**Consultation Response from KC,
Lead Local Flood Authority**

2024/92281 Land adj, 17, Whitehall Road West, Birkenshaw, BD11 2LS

Erection of 23 dwellings

Date Responded: 20th June 2025

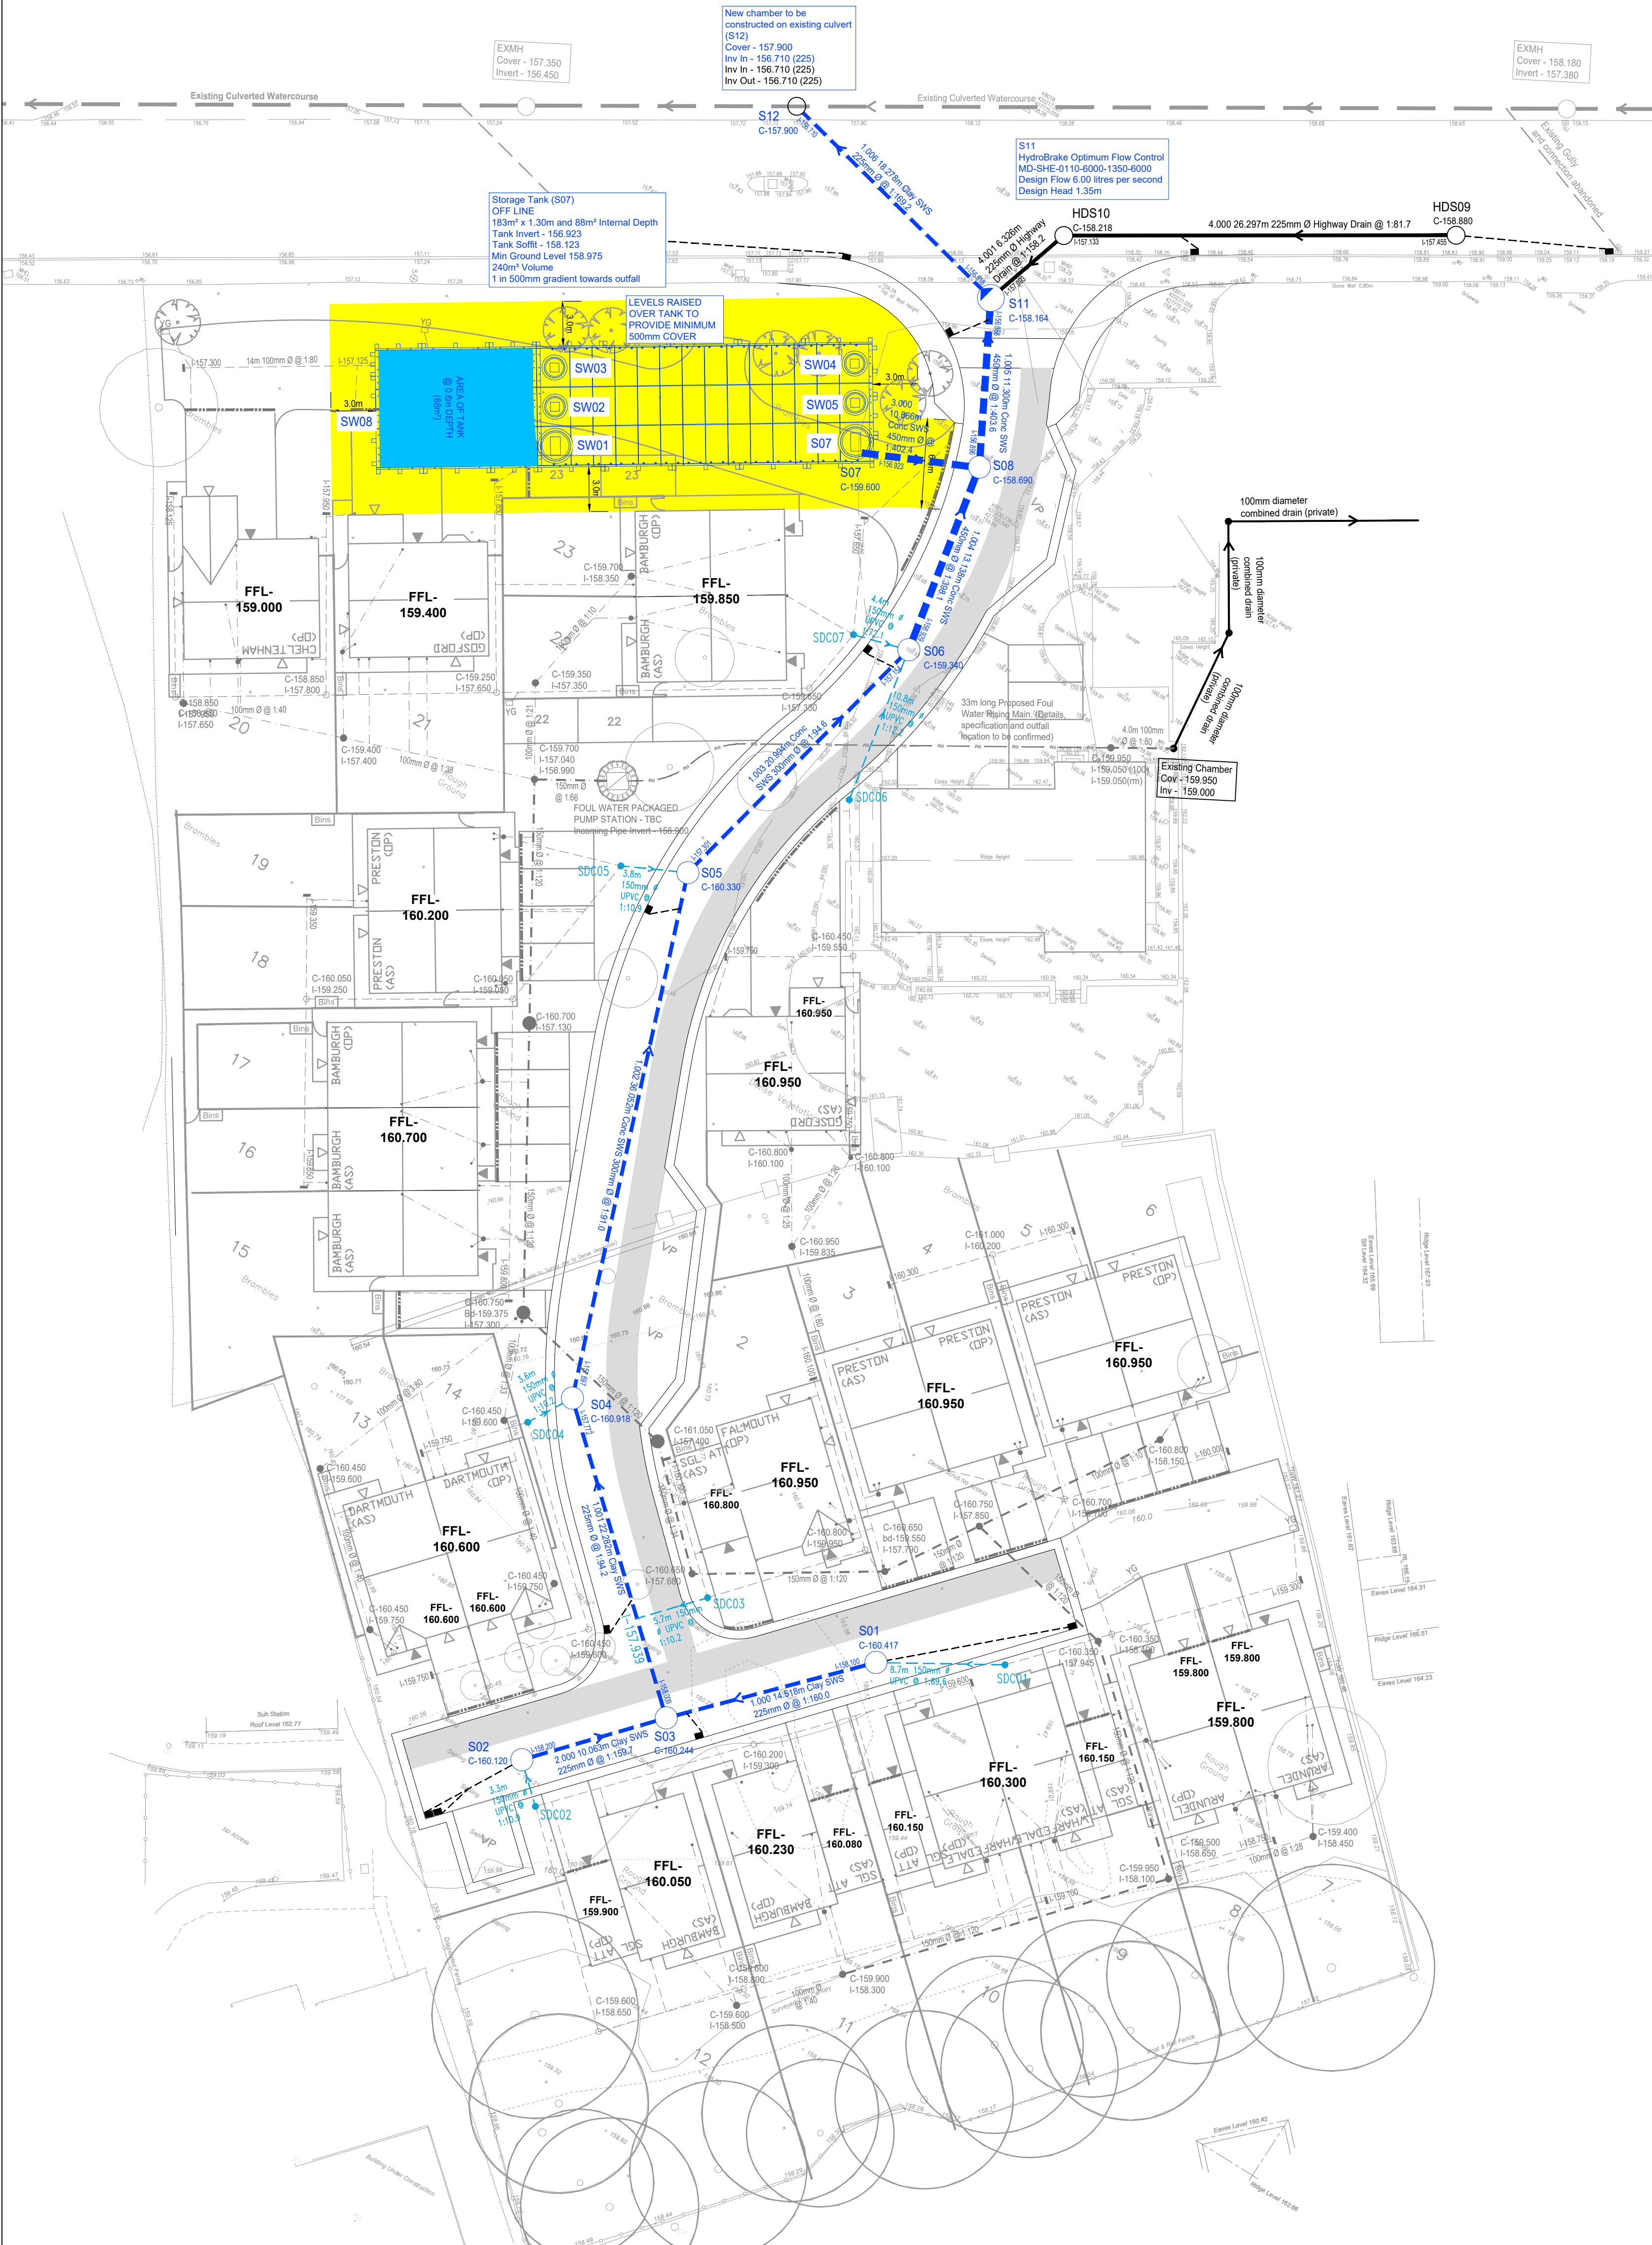
Kirklees Flood Management & Drainage, acting as Lead Local Flood Authority are now satisfied that cover levels on manholes around plot drainage and those for low spots on highways and driveways are now lower than the estimated levels in the attenuation tank for specific crucial return periods and intensities.

The latest submitted drainage plan, flood routing and supporting information is sufficient for approval without conditions.

GA Plan of Tank

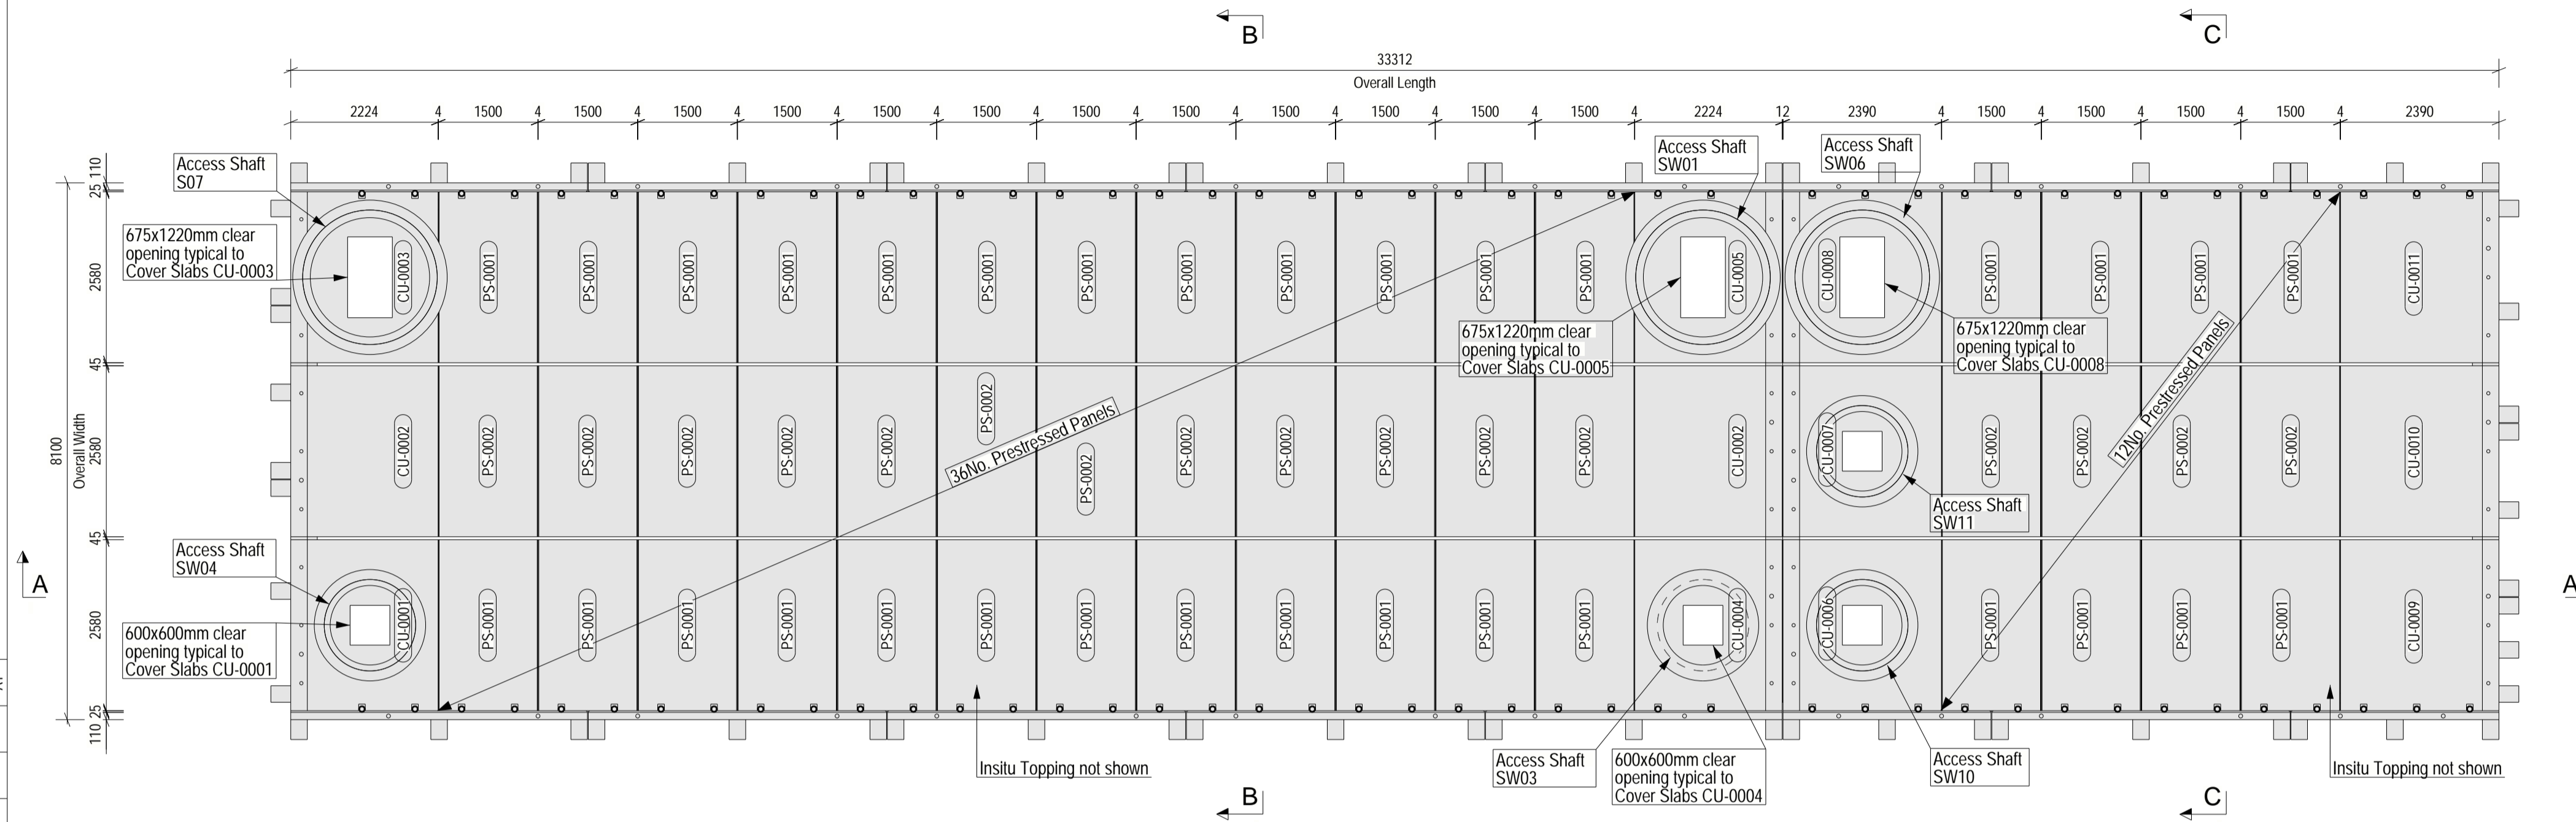
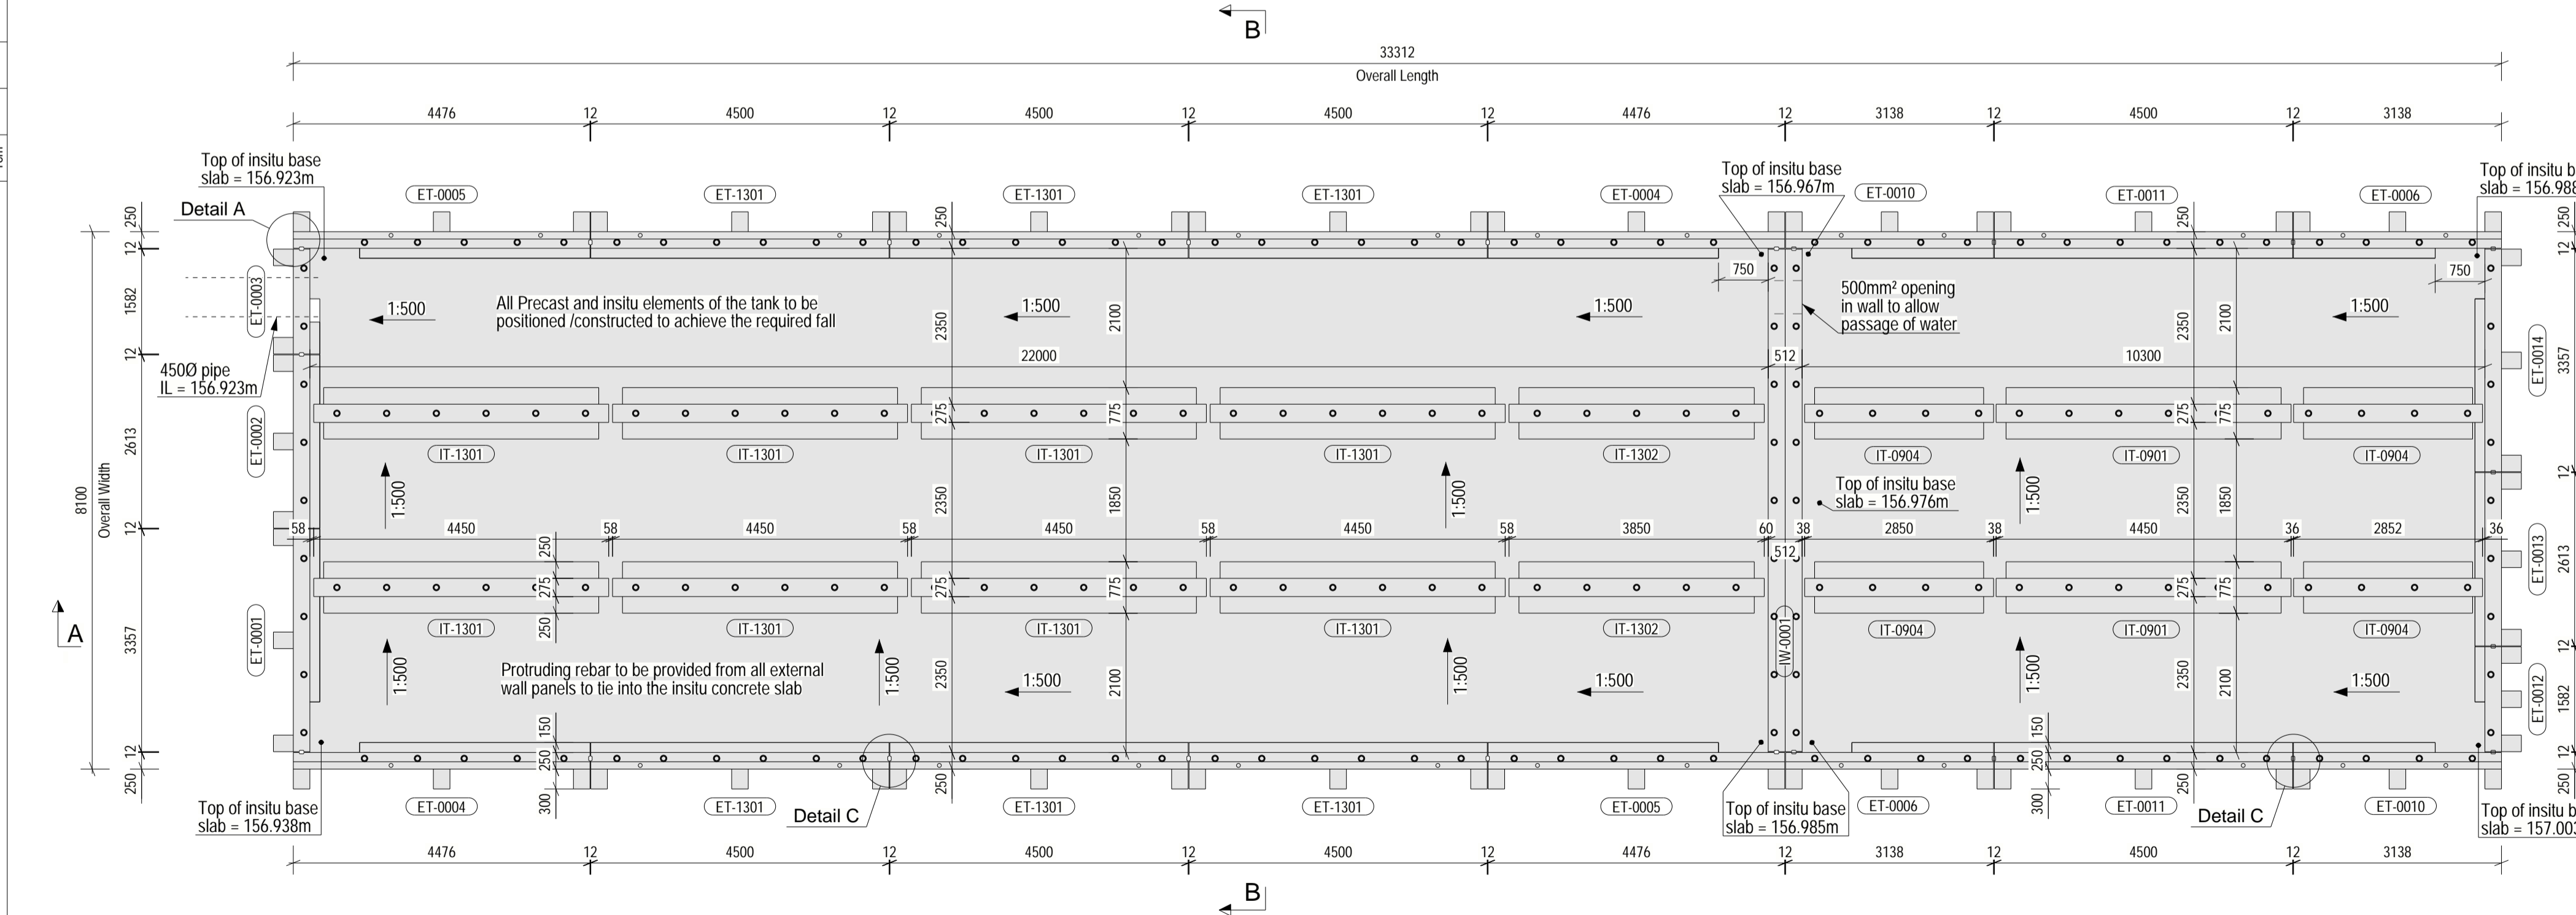
A plan has been submitted for maintenance and management which should be made more bespoke to the tank submitted. This can be conditioned as mentioned on a previous consultation responses.

DR Special Maintenance

The drainage scheme shall include a detailed maintenance and management regime for the storage facility including the flow restriction. This should have a risk assessment applied prior to a method statement consisting of a schedule and itinerary of tasks including access to and into the specific attenuation and flow control arrangements for this site. This is in accordance with design procedures outlines in Construction Design and Management regulations 2015. The provision for a management company to carry out these tasks is laid out in a section 106 agreement (Town and Country Planning Act 1990). There shall be no piped discharge of surface water from the development and no part of the development shall be brought into use until the flow restriction and attenuation works comprising the approved scheme have been completed. The approved maintenance and management scheme shall be implemented thereafter.
